Appeal No: ABP 322787-25

Re: ABP case reference : PL04_322787

Applicant: Tullacondra Green Energy Limited

Proposed wind farm development at Polnareagha, Ardskeagh, Tullacondra, Croughta, Kilmaclenine, Ballyclogh, Knockaunavaddreen, , Copestown, Ballybeg, Baltydaniel East, Twopothouse, Caurraghakerry, Co. Cork .

Figure 2.1: Preliminary Layout Plan

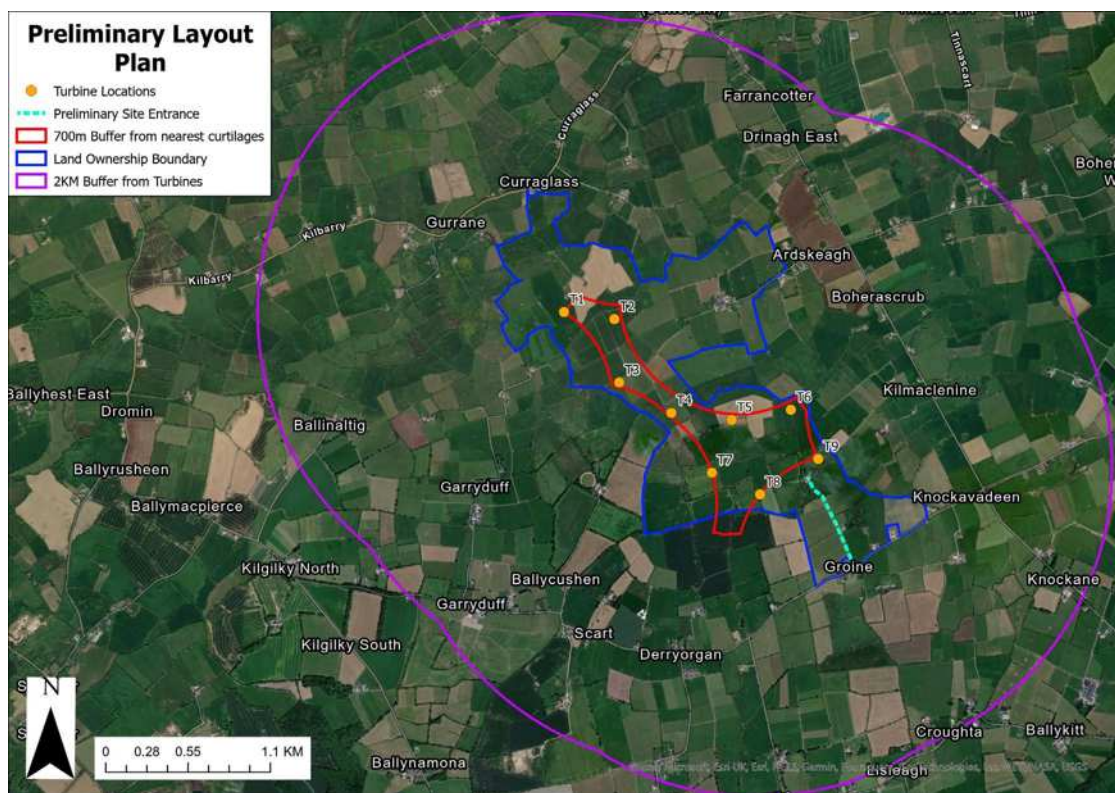
I highly recommend this application be looked at in detail with respect to the turbine to turbine separation distances within this application site boundary. This small landholding is packed with turbines and as tight a design I have come across on approx. 40 designs I have studied in the last two years.

Added to this the Met mast location and its proximity to nearby turbines will render it useless.

IN ABP case reference PL04_322787 to which this observation refers, the applicant has, as one can see in Map 1, (next page) completely ignored the turbine separation distances from adjacent turbines.

As mentioned earlier the Met Mast location for the project beggars belief.

Therefore at least some turbines must be 1050m apart at a minimum in the prevailing wind and no turbine shall be within 450m of another turbine..

Therefore at least some turbines must be 750m apart at a minimum in the prevailing wind and no turbine shall be within 450m of another turbine..

It is my opinion that the developers will not get a valid warranty for the eventual turbine, after their tender process, for a spacing less than 5 rotor diameters in the prevailing wind direction and 3 rotor diameters in other directions. The layout on Map 1 still shows a significant lack of spacing, using the manufacturers recommendations.

1: The manufacturer's specifications for the particular model of turbines used in their design (Vestas V150 4.5MW) with specific reference to the minimum separation distances from turbine to turbine within the windfarm (not windfarm to windfarm).
(Turbine manufacturers recommend separation distances to avoid excess turbulence, wind shear, noise and other impacts on the integrity of the turbines).
This is to enable them provide a warranty for the turbine being used.
